The Coal
Authority

PLANNING APPLICATION: 2023/62/91116/E

**Erection of 67 dwellings at Land off Primrose Lane, Hightown, Liversedge -
RECONSULTATION**

The Coal Authority Response: Substantive Concern

PRIMROSE LANE
 PROPOSED SITE LAYOUT

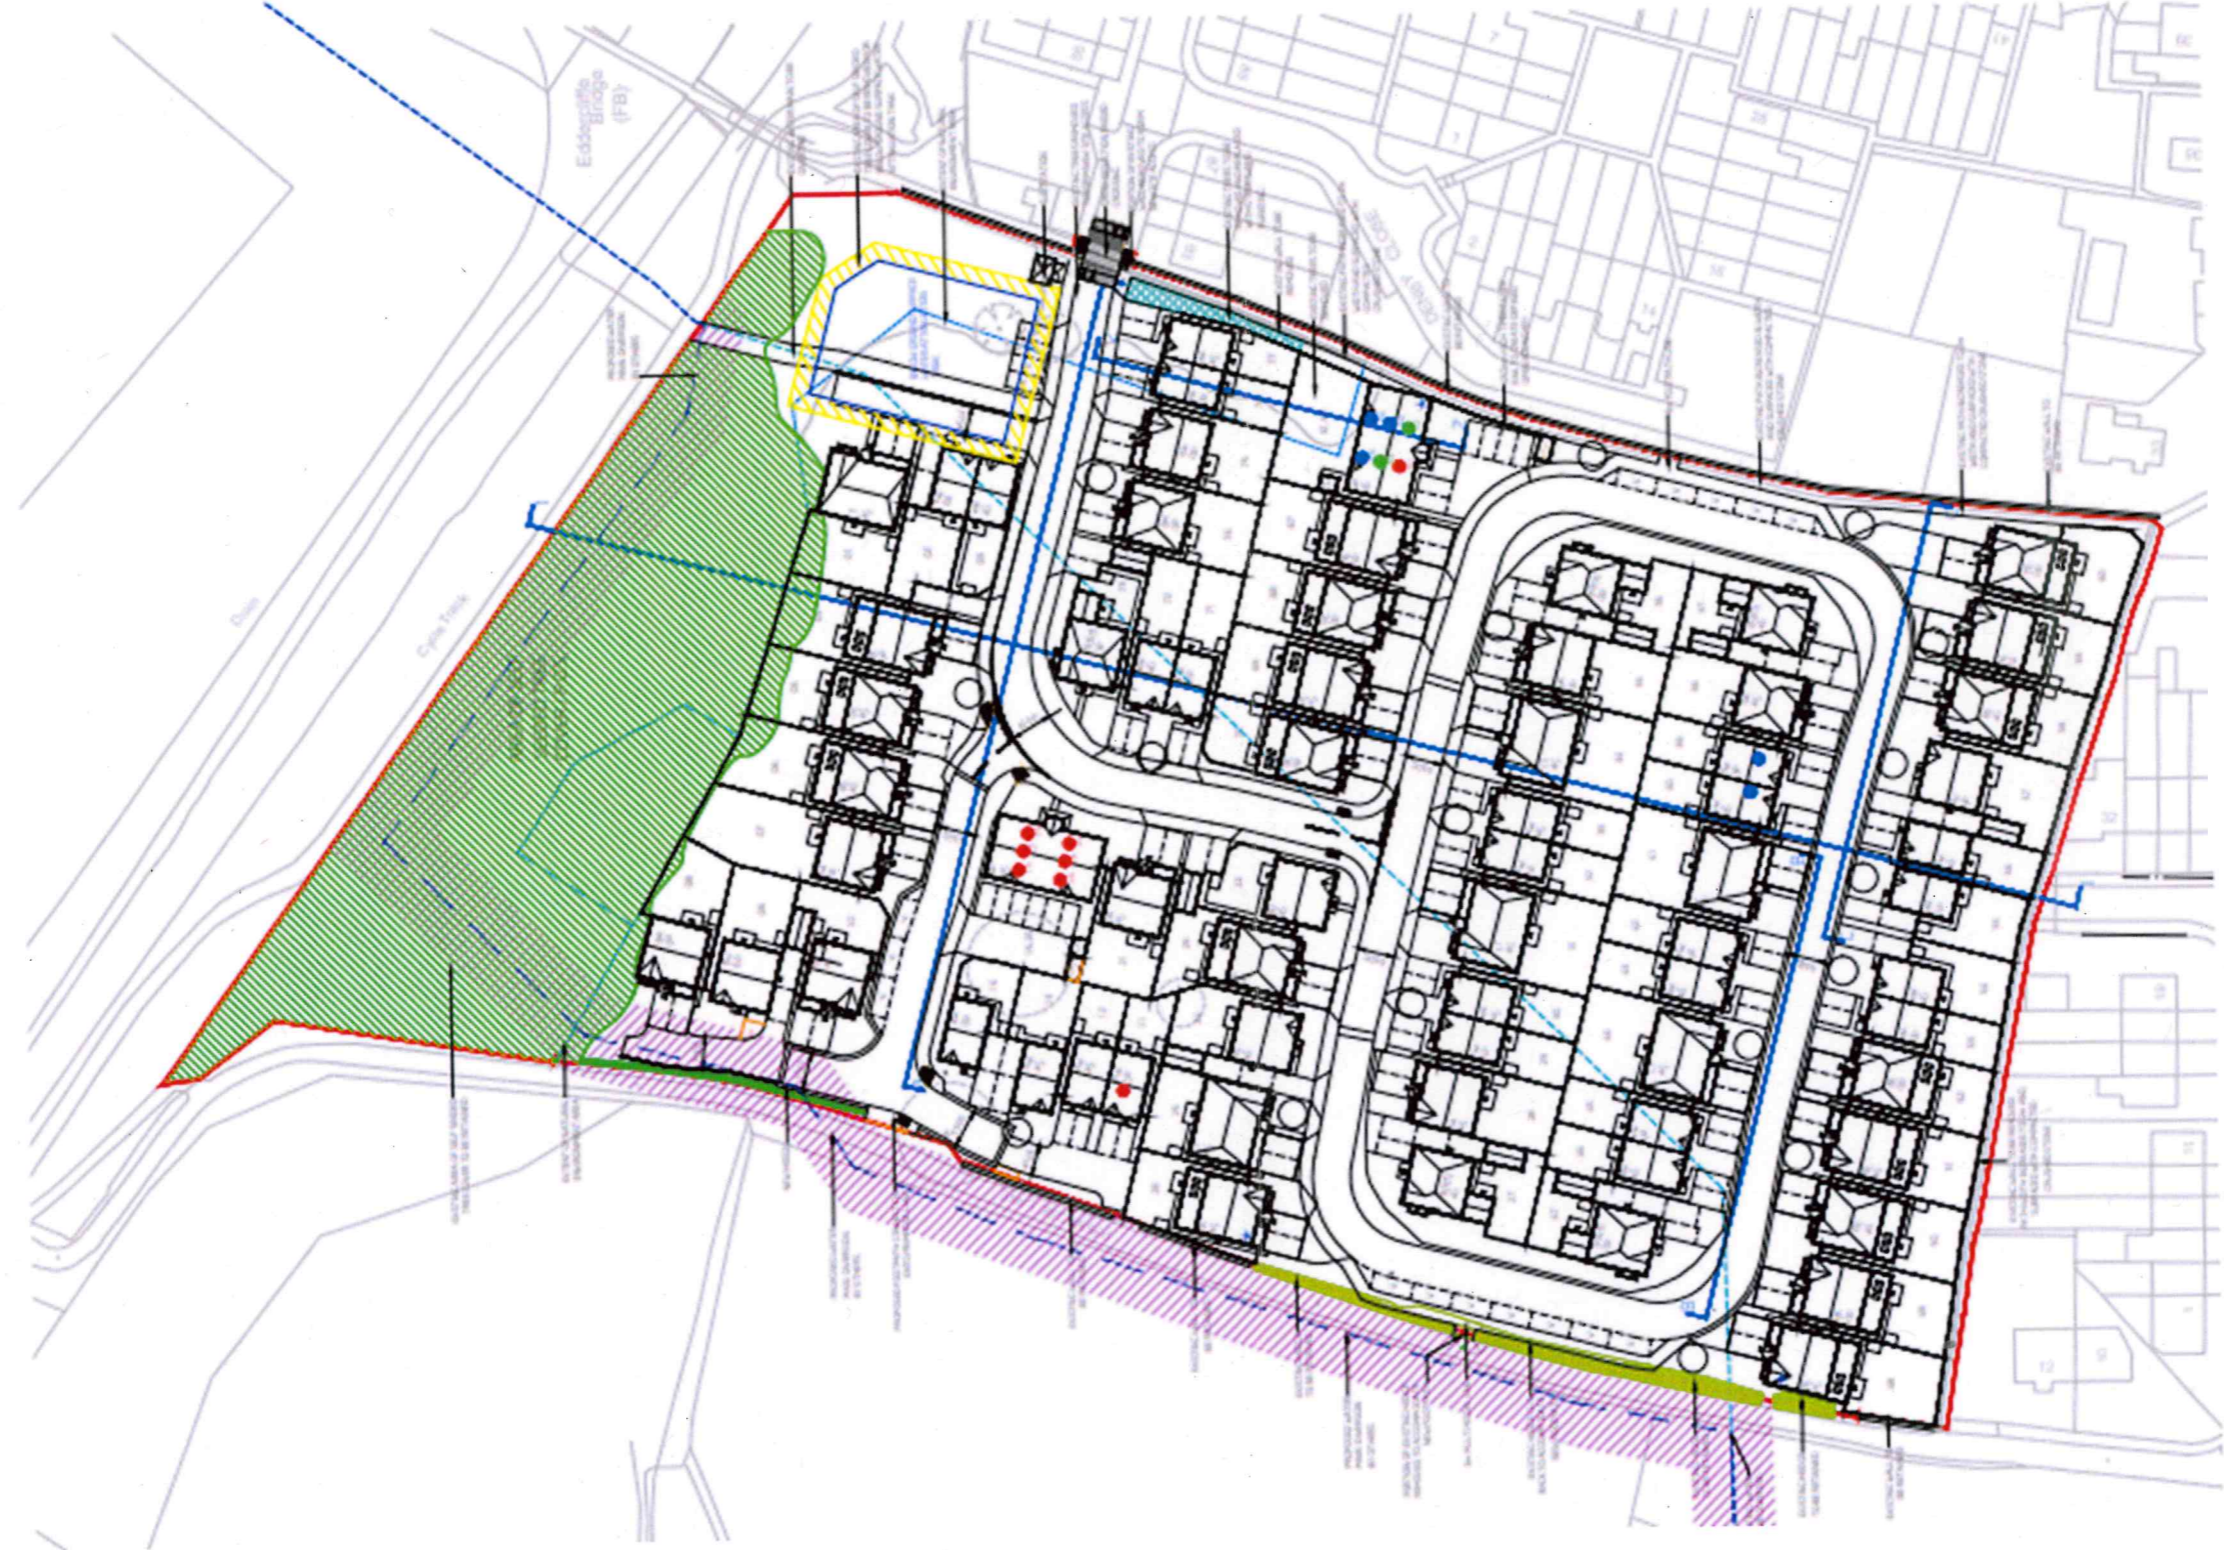
We last commented on this application in a letter to the LPA dated 31 May 2023. In this letter, we objected to the proposal due to concerns that it had not been demonstrated that the proposed layout of development had been suitably informed by the presence of the mine shafts and their associated zones of influence, with buildings proposed close to or potentially over these features.

We went on to advise that intrusive investigations should be carried out prior to the determination of the application in order to locate all recorded shafts present within the site, including establishing the adequacy of any past remedial treatment works. We advised that the information gained from these investigations should be used to make any necessary revisions to the proposed layout to ensure that built development avoids the shafts and their associated zones of influence.

The Coal Authority's Planning & Development Team welcomes the investigatory works carried out to-date. However, the submitted information does not satisfactorily address the concerns set out in our initial consultation response letter. We must therefore **maintain our objection** to the application.

The applicant should be advised of our continued objection and requested to undertake further investigations to fully establish the risks posed by the recorded mine entries to the proposed development, to identify appropriate remedial and mitigatory measures to address these risks and to make any necessary revisions to the proposed detailed layout of development.
